**DELEGATED DECISION FOR APPLICATION FOR CERTIFICATE OF
LAWFUL DEVELOPMENT**

Reference no.: 2026/CL/90882/W

Site: 80, Blagden Lane, Newsome, Huddersfield, HD4
6JZ

Description: Certificate of lawfulness for proposed erection of
single storey side extension

Scale:	Drawing Number:	Rev.:	Date Drawn:	Drawn By:
1/50 & 1/100	2026/008/03		March 2026	Andrew Smith

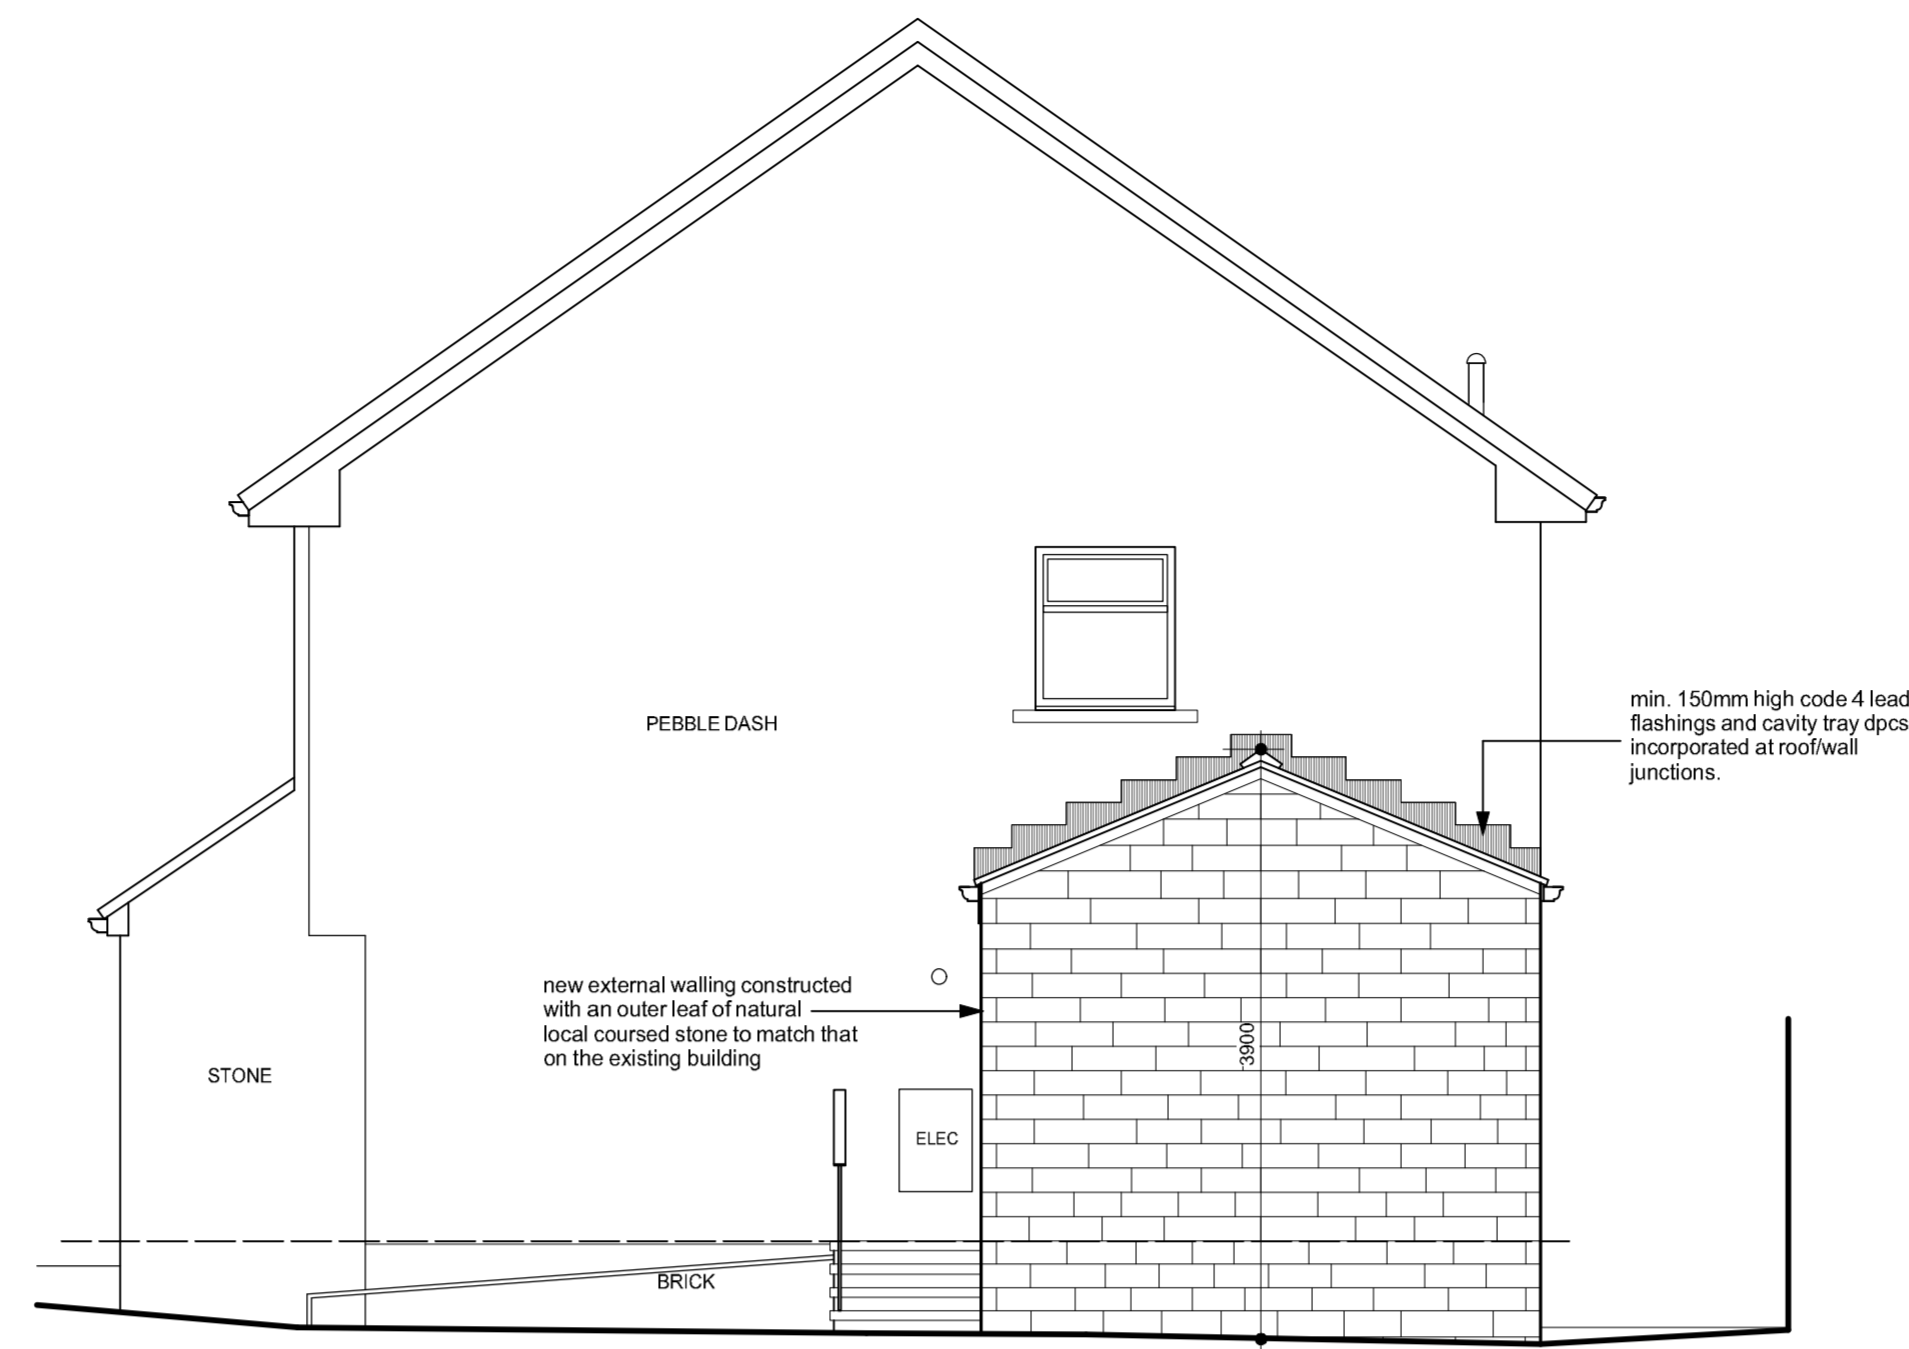
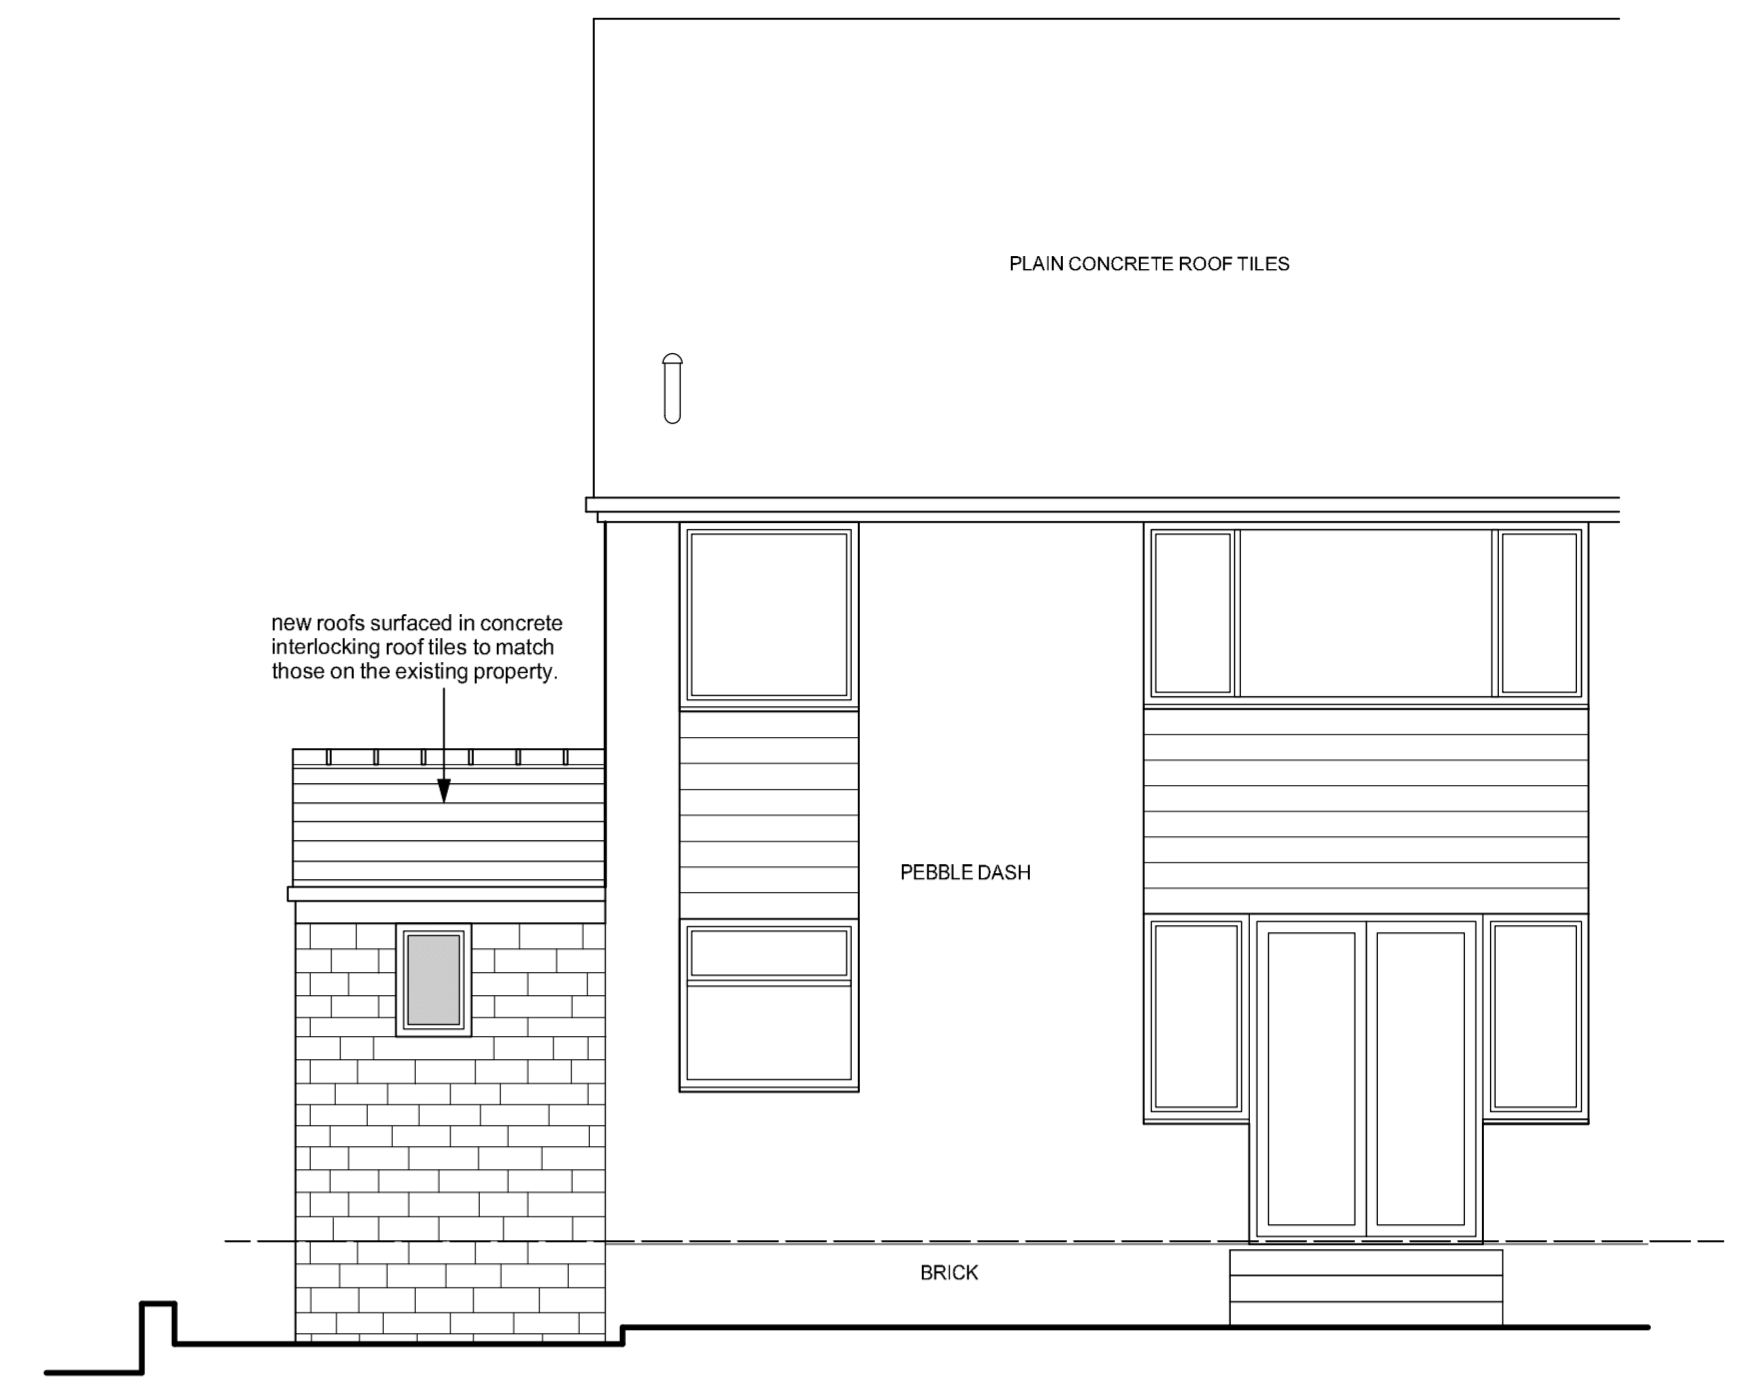
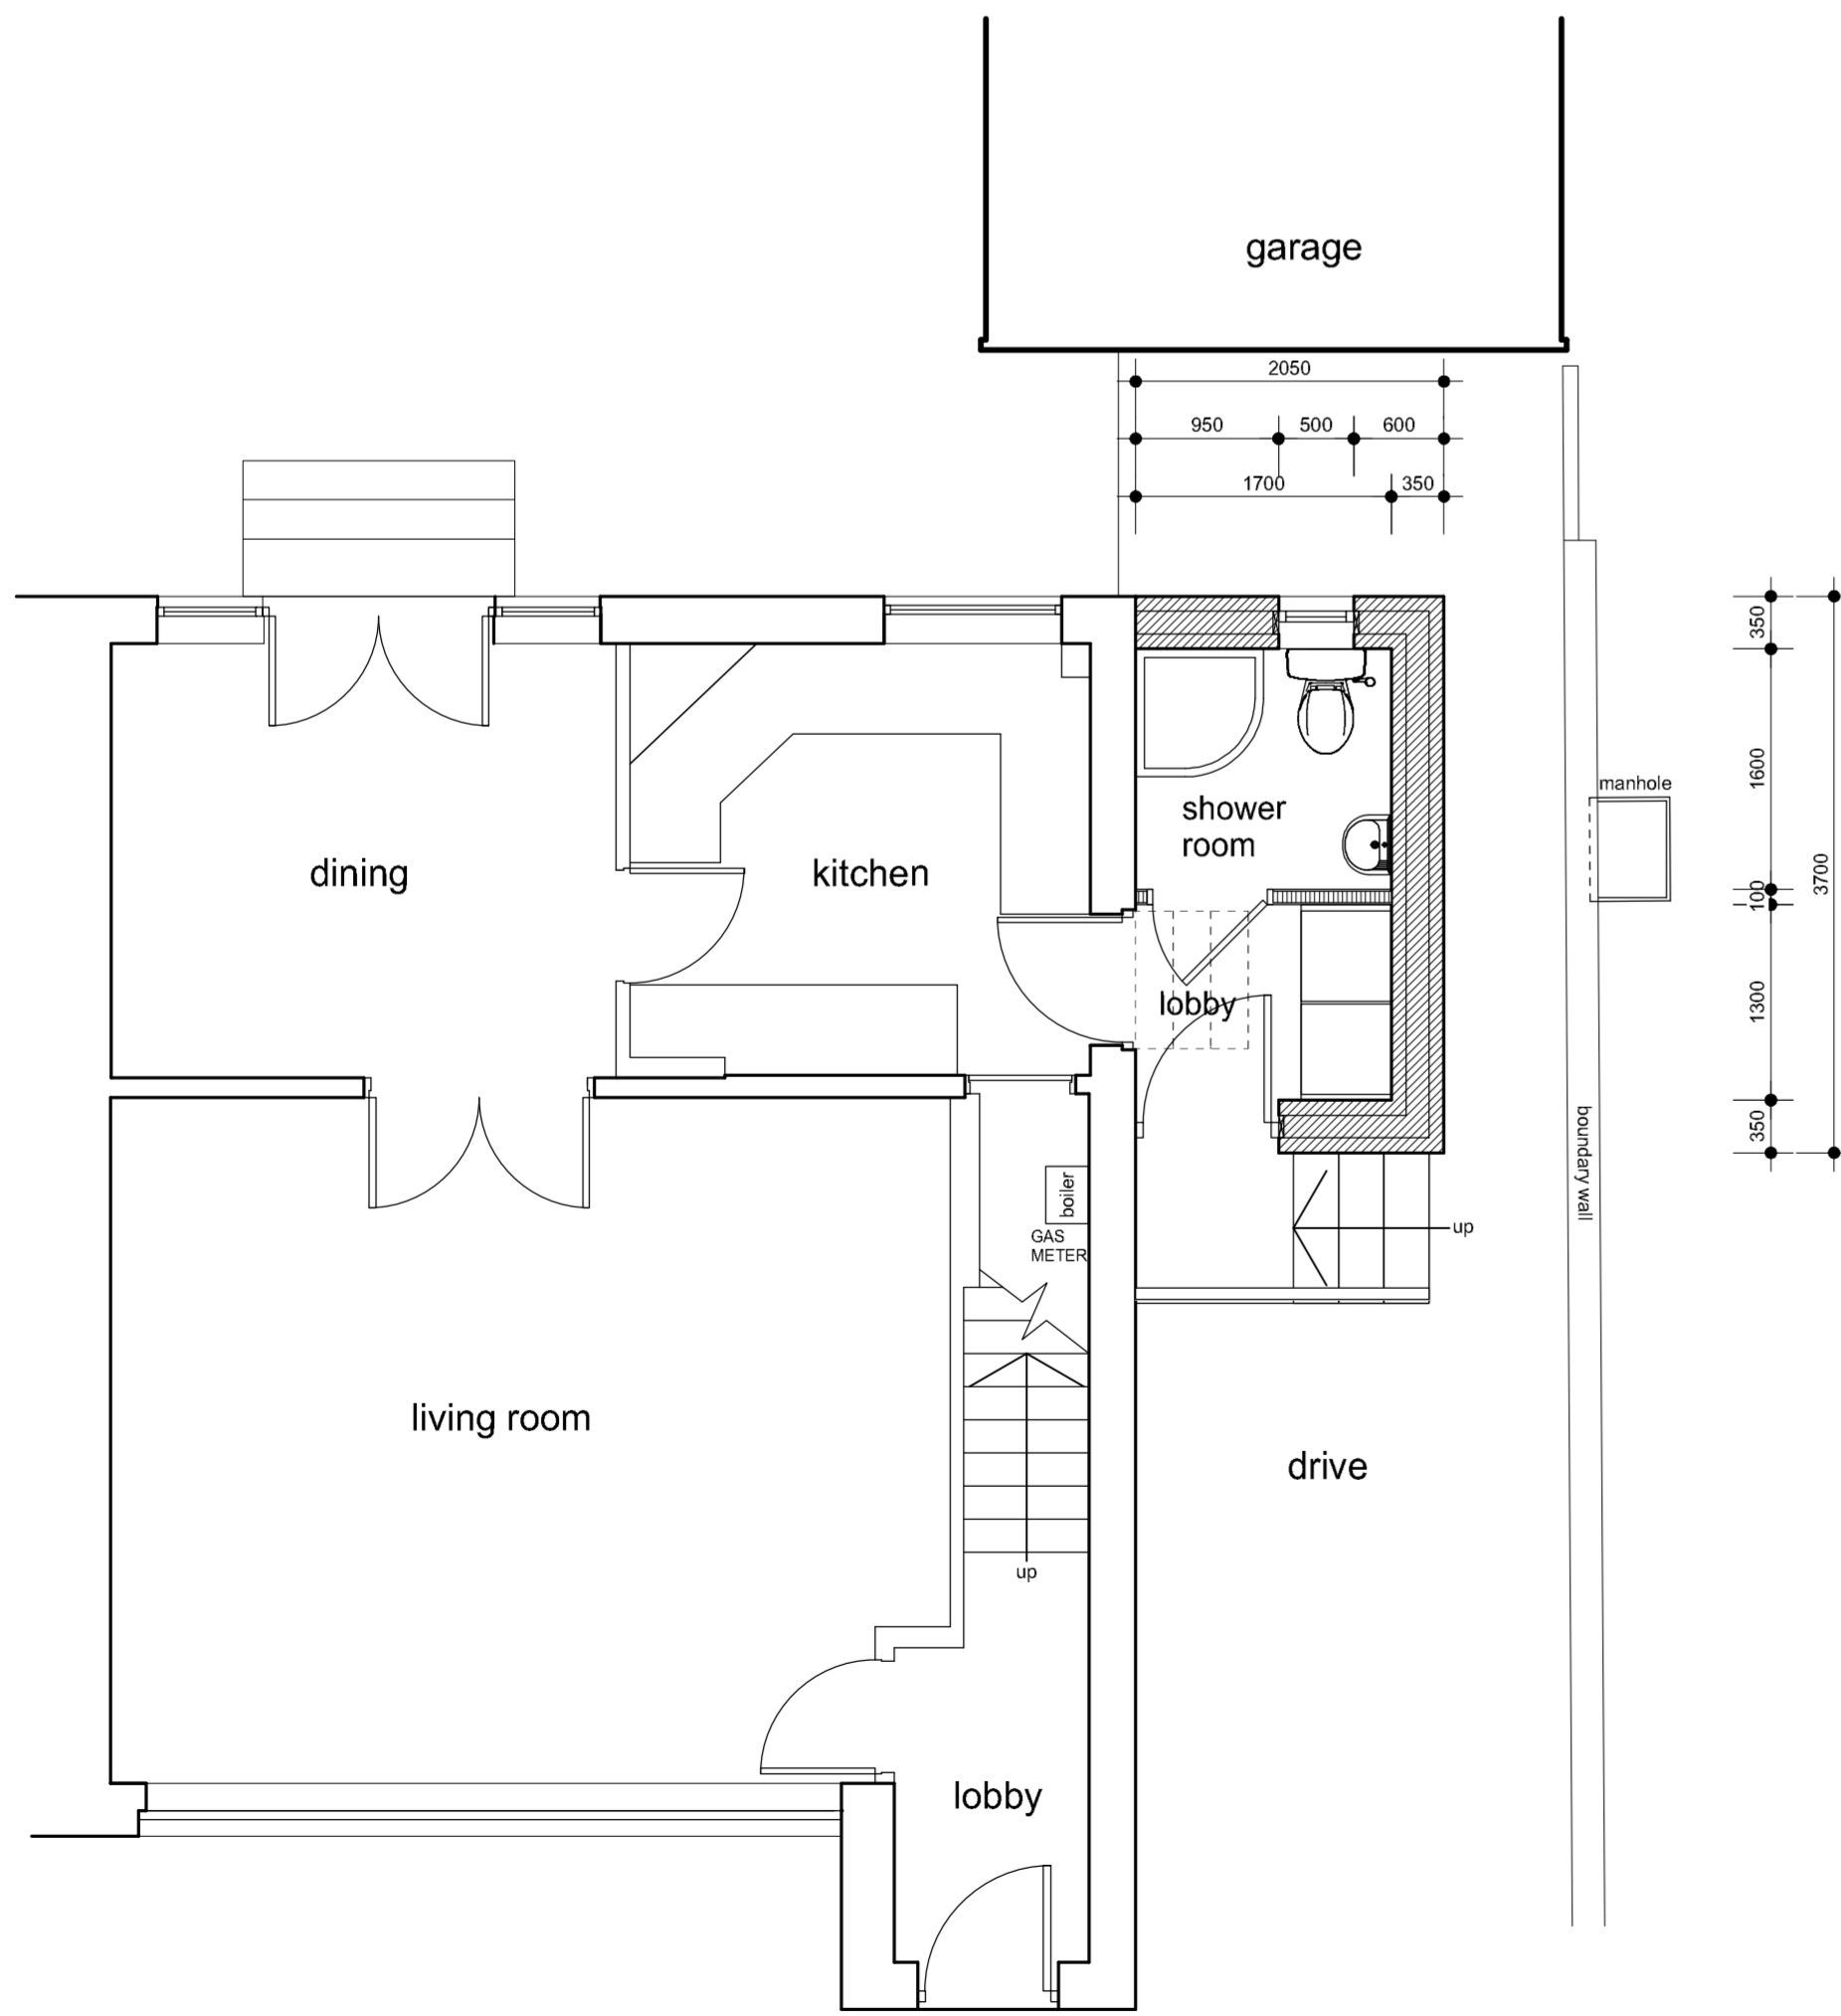
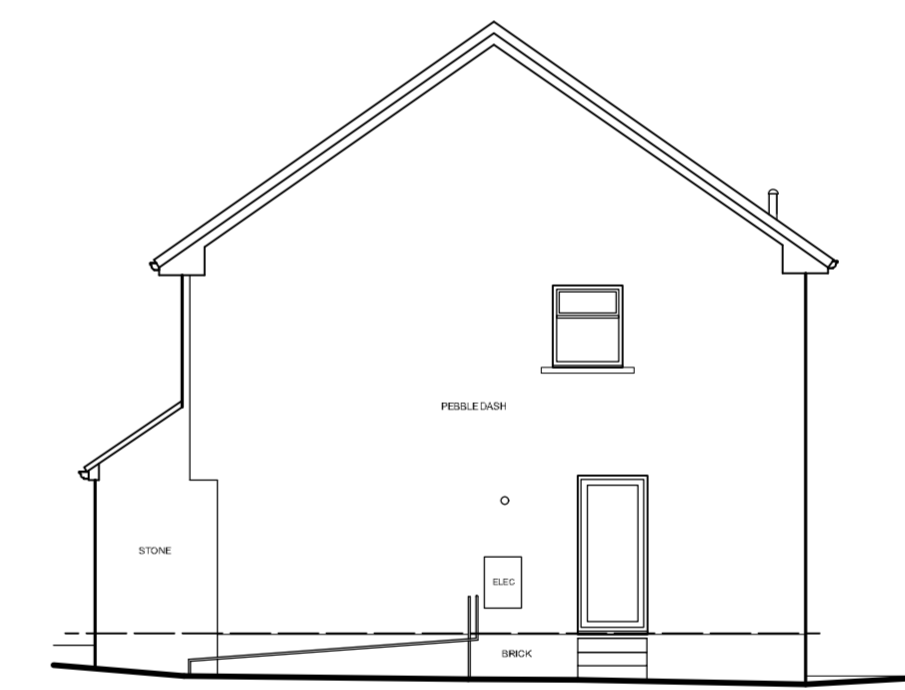
The proposed extension/enlargement would be set back from the front elevation by 5.7 metres lying flush with the existing rear elevation of the property. The extension/enlargement would project to the side by 2 metres with an eaves height of 2.9 metres and overall height of 3.9 metres.

It is proposed that extension/enlargement would be accessed via external steps.

Comment: *The height of the enlargement would not exceed the highest part of the roof of the existing dwellinghouse.*

Comment: *The height of the eaves of the enlargement would not exceed the height of the eaves of the existing dwellinghouse.*

Comment: *The enlarged part of the dwellinghouse would have a single storey. It would not extend beyond the rear wall of the original dwellinghouse or exceed 4 metres in height.*

Comment: *The enlarged part of the dwellinghouse would be within 2 metres of the boundary of the curtilage of the dwellinghouse however the height on the eaves of the enlarged part would not exceed 3 metres.*

Comment: *The enlarged part of the dwellinghouse would extend beyond a wall forming a side elevation of the dwellinghouse. It would not exceed 4 metres in height, would not have more than a single storey and would not have a width greater than half the width of the original dwellinghouse.*

Comment: *None of the above are shown on plan. However, it is proposed that a small external staircase would be relocated to facilitate access into the single storey extension. Whilst a raised platform would be created, this would not provide any 'meaningful' raised platform or balcony accommodation due to its limited size and provides external access to the curtilage of the dwellinghouse, Under these circumstances, the works solely to provide access to the dwellinghouse are not considered to fall under the definition of a development.*
